From: Walker, Angela [REDACTED]
Sent: 10 November 2017 11:11
To: Simon Davis
Cc: [REDACTED]
Subject: RE: The Whyke House, 47 Felpham Way - FP/175/17/L

To: Walker, Angela [REDACTED]
Subject: The Whyke House, 47 Felpham Way - FP/175/17/L

EXISTING & PROPOSED ELEVATIONS

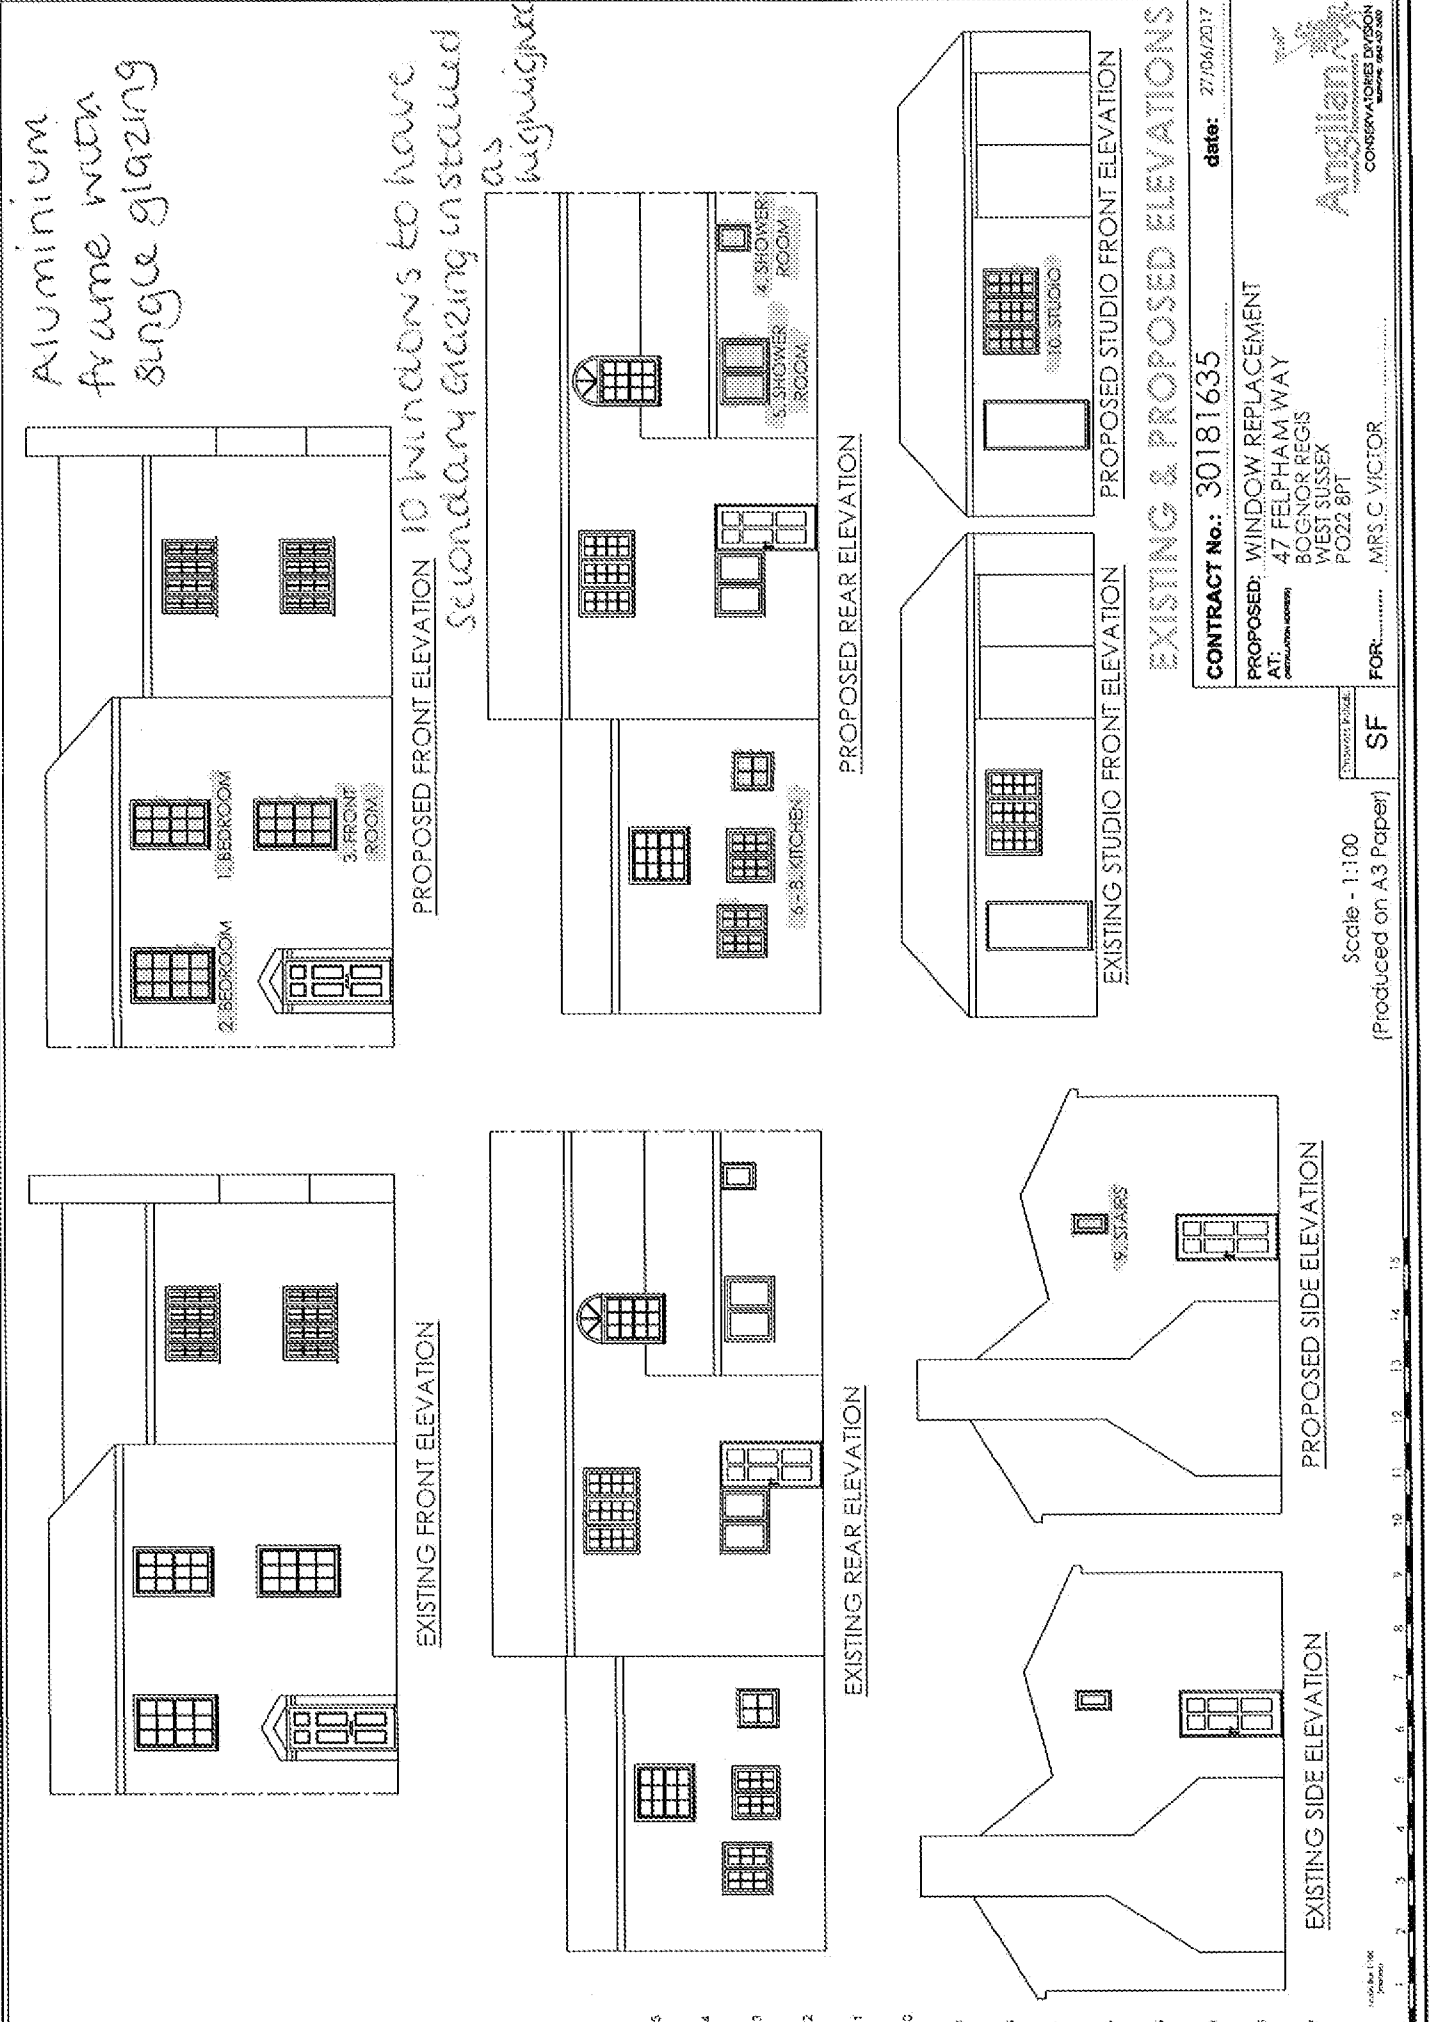
"Generally, I'd say no to this, as secondary double glazing is as intrusive visually as double-glazing. That is to say there are two layers of reflectivity which inevitably has an adverse effect on the appearance of the property as a whole. In this case, secondary glazing would also encroach on the historic timber window reveals (and possibly shutters – although they have not photographed all windows). In addition to this, the submitted photographs (towards the end of the application), show secondary glazing already in situ. This appears to be unauthorised, and should be removed."

Can you comment on the secondary glazing shown in the photos. It is not clear; are these photos of existing windows in the property or are they of a completely different property?

With regards to the point made about the two layers of reflectivity we would like to highlight that the windows to the rear of the property are not overlooked so would not be intrusive to the community. In addition, as the purpose of secondary glazing is to allow the home owner a level of control of heat, in the warmer months when the sun is most likely to reflect on the glass the secondary glazing would be open and only in the colder months, when they would be closed there sun reflection would not be an issue.

Secondary glazing is not a permanent structure and is fully removable and therefore the original windows remain untouched and can be maintained in the future to ensure their further longevity.
